North Tower Response to OSD and Metro DRP Feedback

DRP 7 North Tower

SMMP—ISD

18 December 2018

Figure 5. Plan — Stage 2 SSD DA Elizabeth Street Metro Entrance

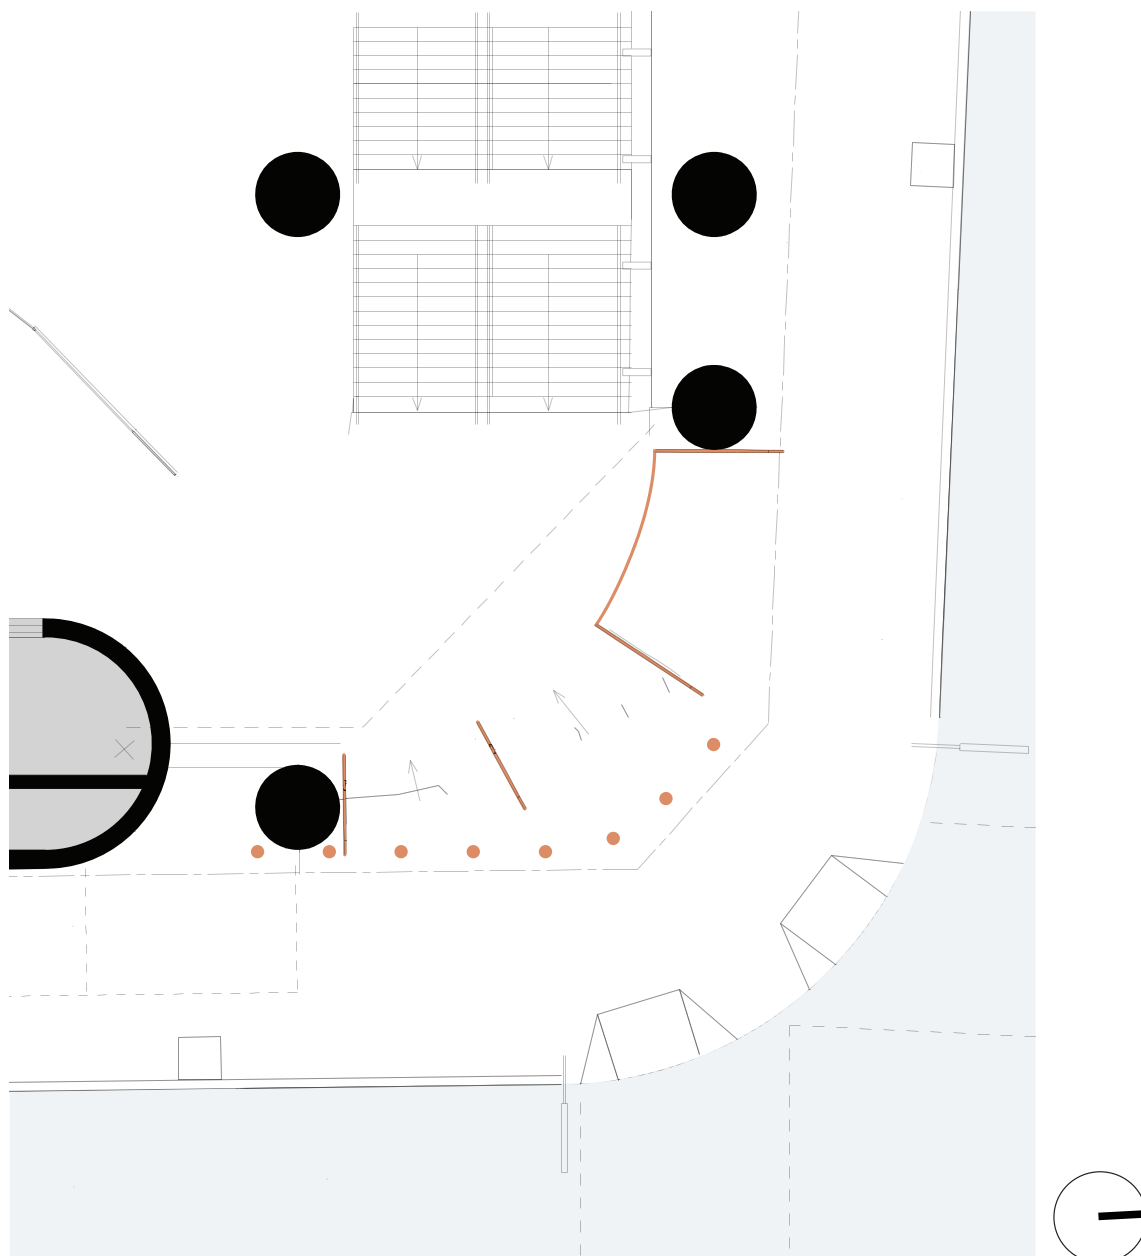
- C** “While the proposal for stairs creates a more welcoming corner entrance, the building’s interface with Hunter Street is unresolved. We are **concerned about the spaces between the building and columns** on the northern elevation.
- A** We also emphasise the need for the **disabled access** off Elizabeth Street, which occurs between columns, **to be made as generous as possible.**”
- D** “While we support the awning proposal, we recommend it be lowered as far as possible to improve weather protection, particularly that portion of the awning which is raised to mark the entrance to the through site link.”

- B** • The building’s interface with Hunter Street still requires improvement, particularly to **avoid the sections of feathered steps.**
- C** • The **areas between the columns and footpath to Hunter are not optimised** and lack a positive civic presence.
- A** • Access to the **disabled entry** on Elizabeth Street needs to be as **generous in width as possible.**”
- D** “The Panel encourages further review of the awning at the entry to the mid-block connection to **ensure that the station entry has an appropriate clarity and identity.**”

OSD DRP comment:

*“We also emphasise the need for the disabled access off Elizabeth Street, which occurs between columns, to be made **as generous as possible.**”*

Station DRP comment:

*“Access to the disabled entry on Elizabeth Street needs to be **as generous in width as possible.**”*

OSD DRP comment:

“Further design refinement is required to address **how the seating steps meet the column** on the northern elevation.”

Station DRP comment:

“The building’s interface with Hunter Street still requires improvement, particularly to **avoid the sections of feathered steps**.”

“Further design development to **avoid feathered steps** at the Elizabeth Street entry and to provide the appropriate civic response along Hunter Street.”

Figure 6. Plan — Design development strategies Elizabeth Street Metro Entrance

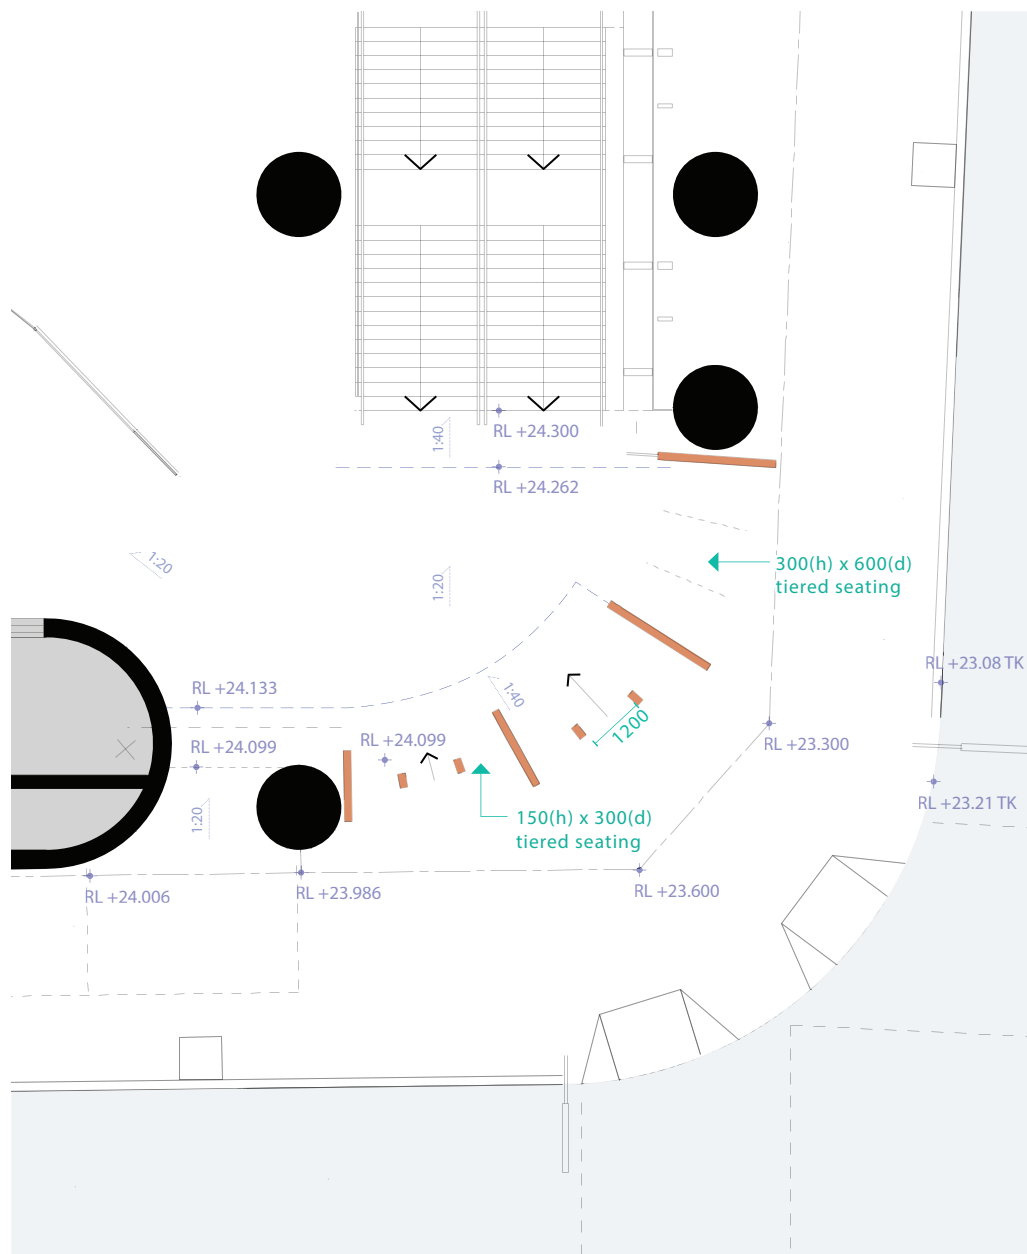
- B** “Further design refinement is required to **address how the seating steps meet the column on the northern elevation.**”
- C** We recommend **consideration of opportunities for public seating** between the columns on the northern elevation to Hunter Street.”
- D** “Further design refinement is required to **ensure the awnings which mark entrances to public and private spaces are differentiated.**”

- B** “Further design development to **avoid feathered steps** at the Elizabeth Street entry and to provide the appropriate civic response along Hunter Street.”
- D** “Further design review of the awning above the entry to the mid-block connection on Elizabeth and Castlereagh Streets to ensure the awnings serve their intended purpose of weather protection and **give the station entry sufficient clarity / visual identity.**”
